Outline application with all matters reserved for 22 No. new dwellings consisting of 2 No. 1 bed dwellings, 18 No. 2 bed dwellings & 2 No. 3 bed dwellings.

26 Burnham Avenue Bognor Regis

Thank you for your internet representation made on 1st April 2019 which has been recorded as '**an objection**' with the comments as follows:

Streetscape (Proposed) 1:100
0 2.5 5.0 M

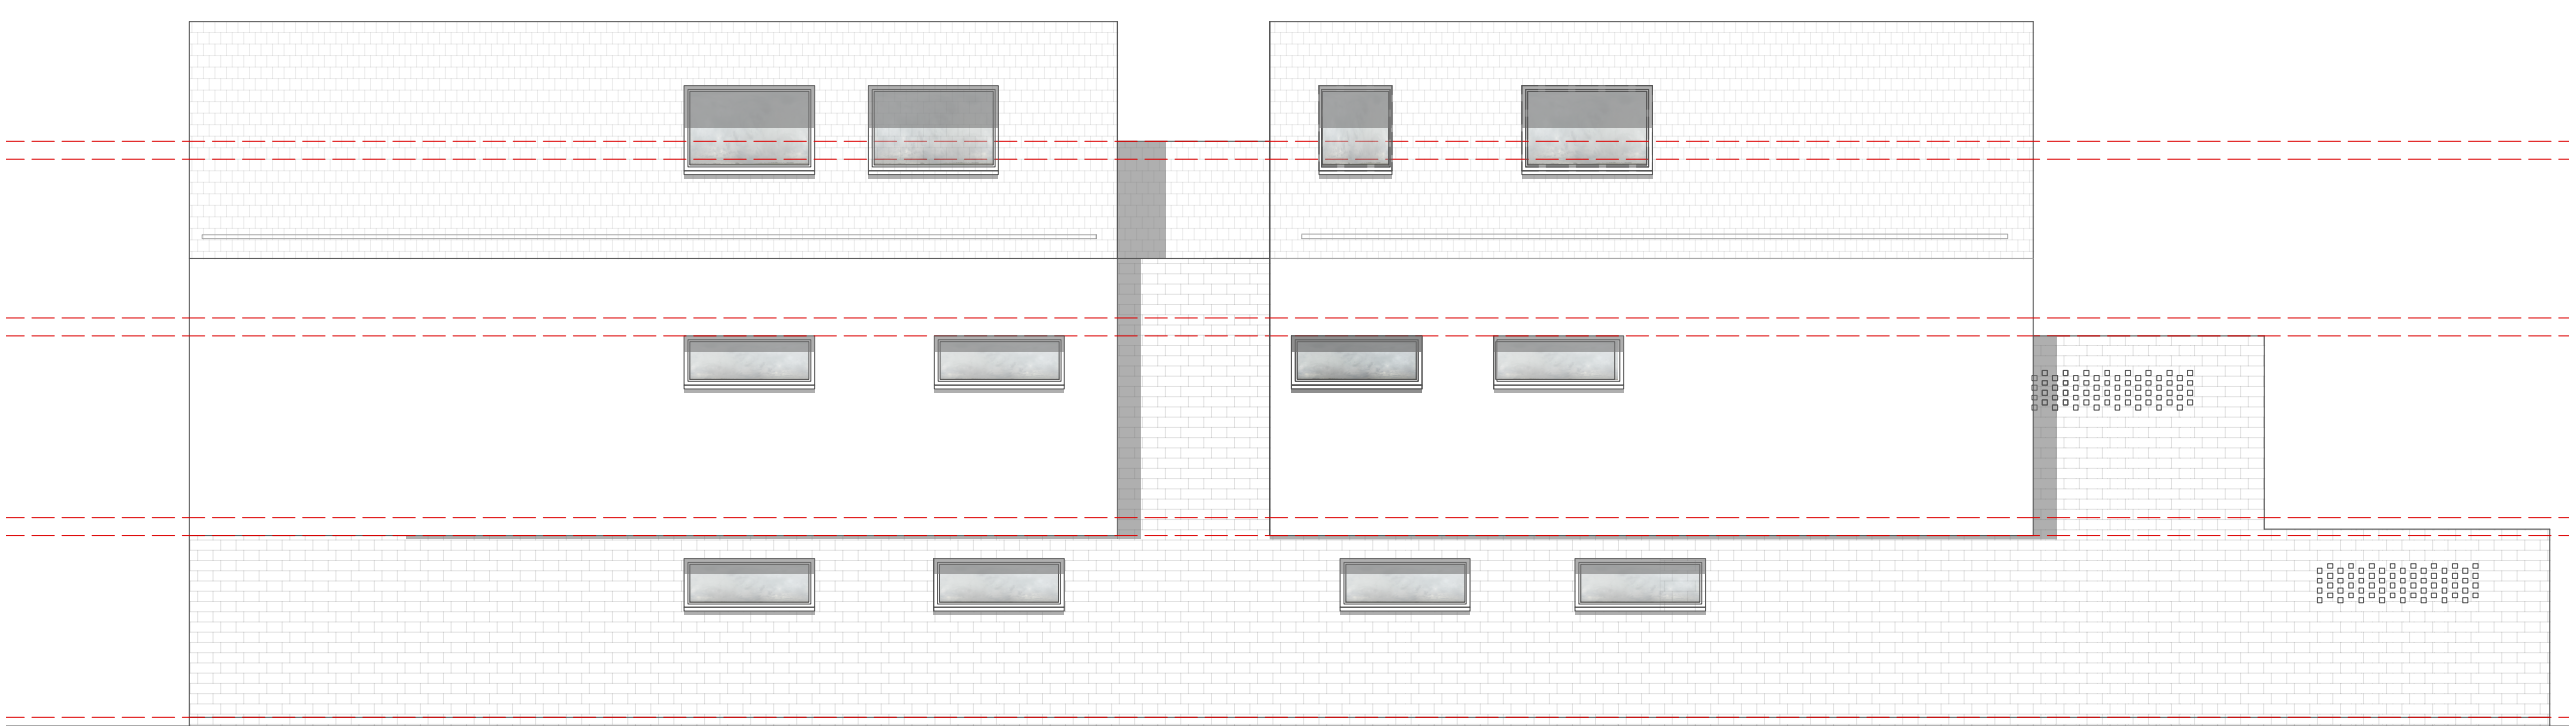
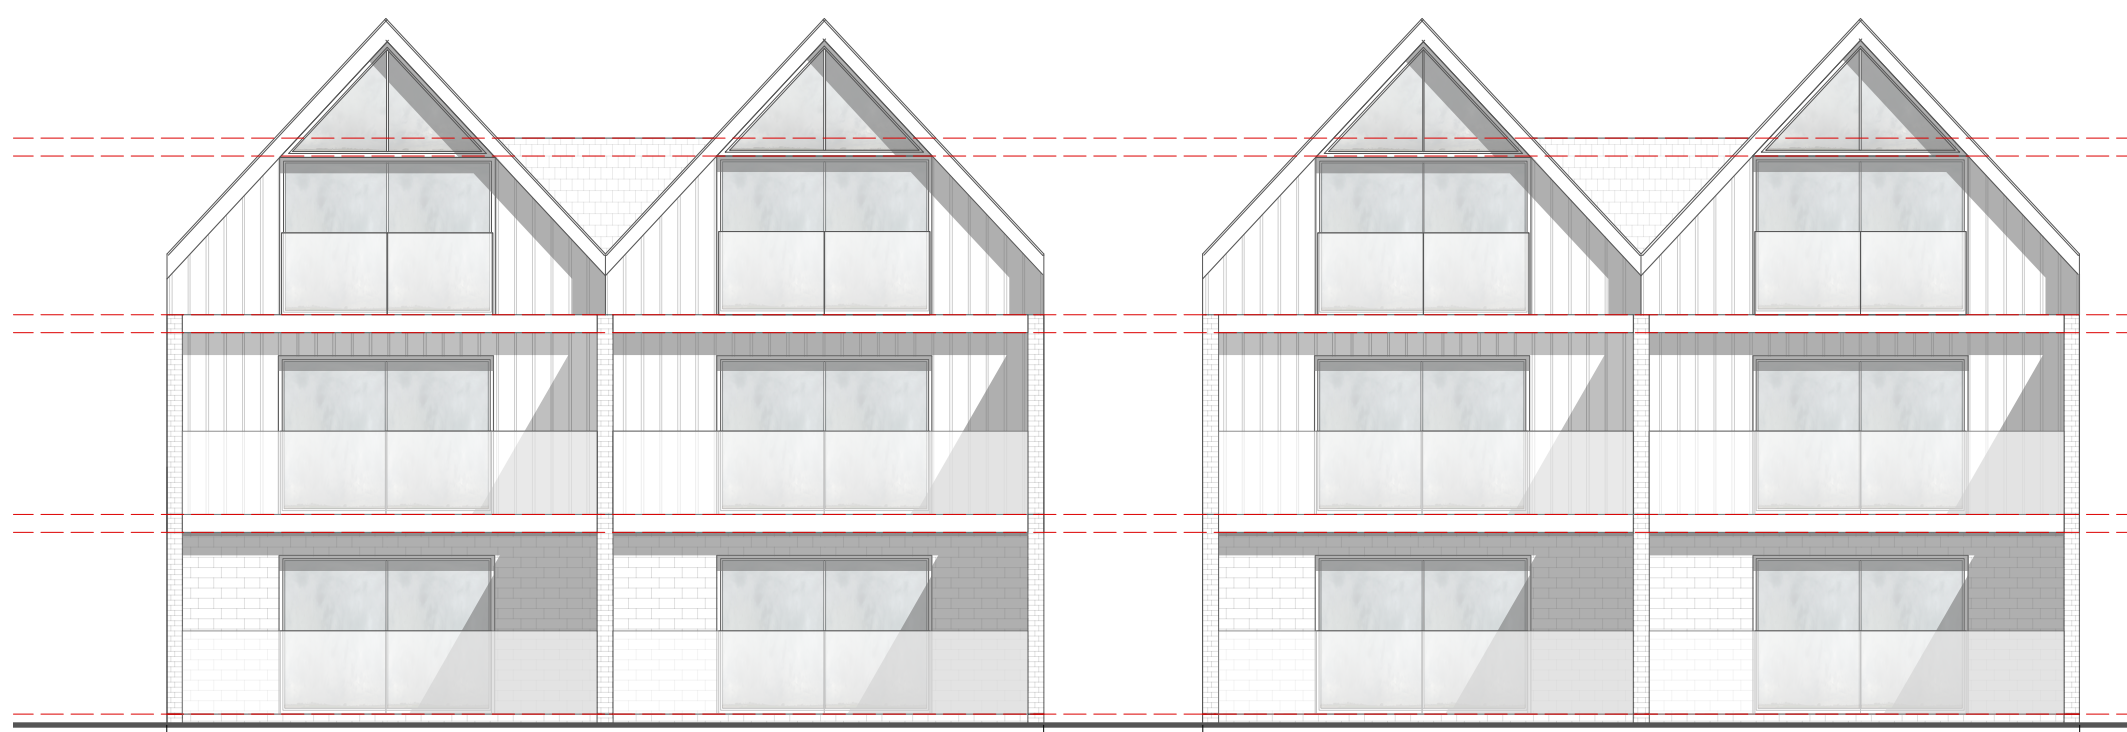
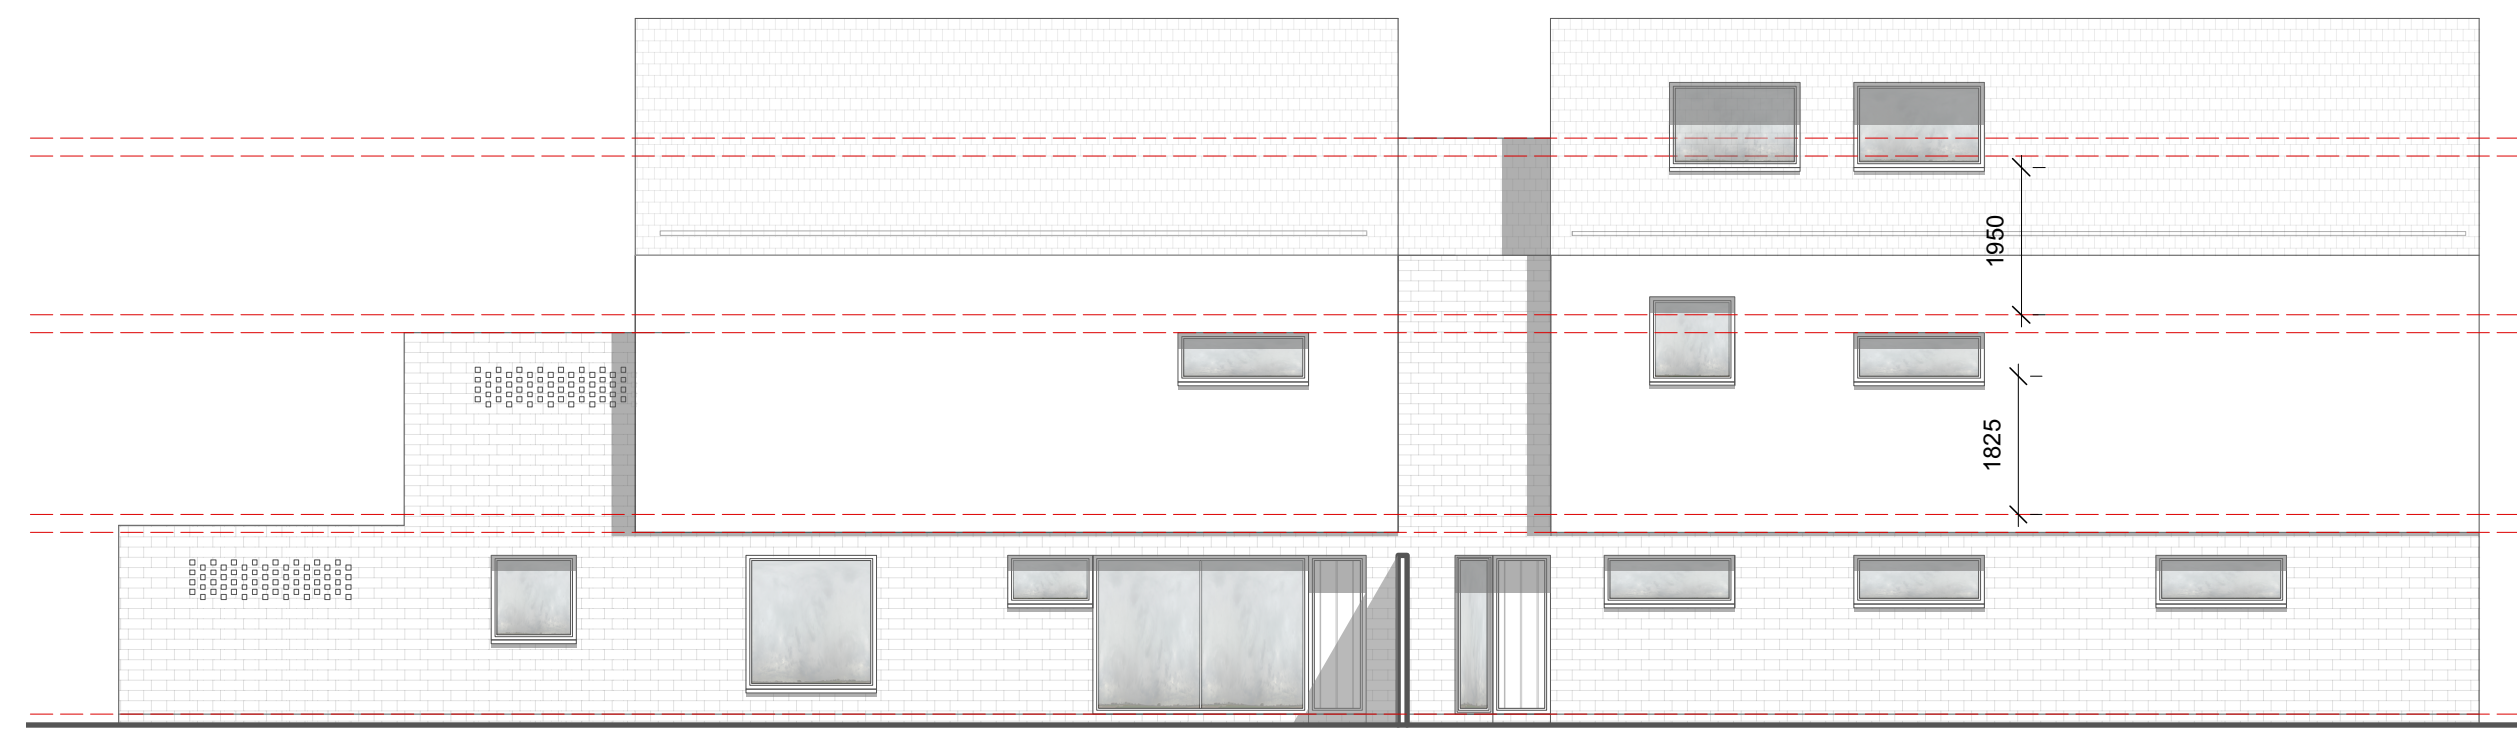
The planned development is totally out of keeping with the style and character of this residential road which has mostly detached, semi detached and terraced houses and there is no other example of housing of the proposed type. A development of this design would be totally unsuitable and detrimental to the area.

There are no gardens or green spaces planned for this housing block and this will add to the loss of wildlife and a huge increase in air, noise and general pollution. This goes against all advisable planning guidelines which should be to improve the quality of life, not destroy it.
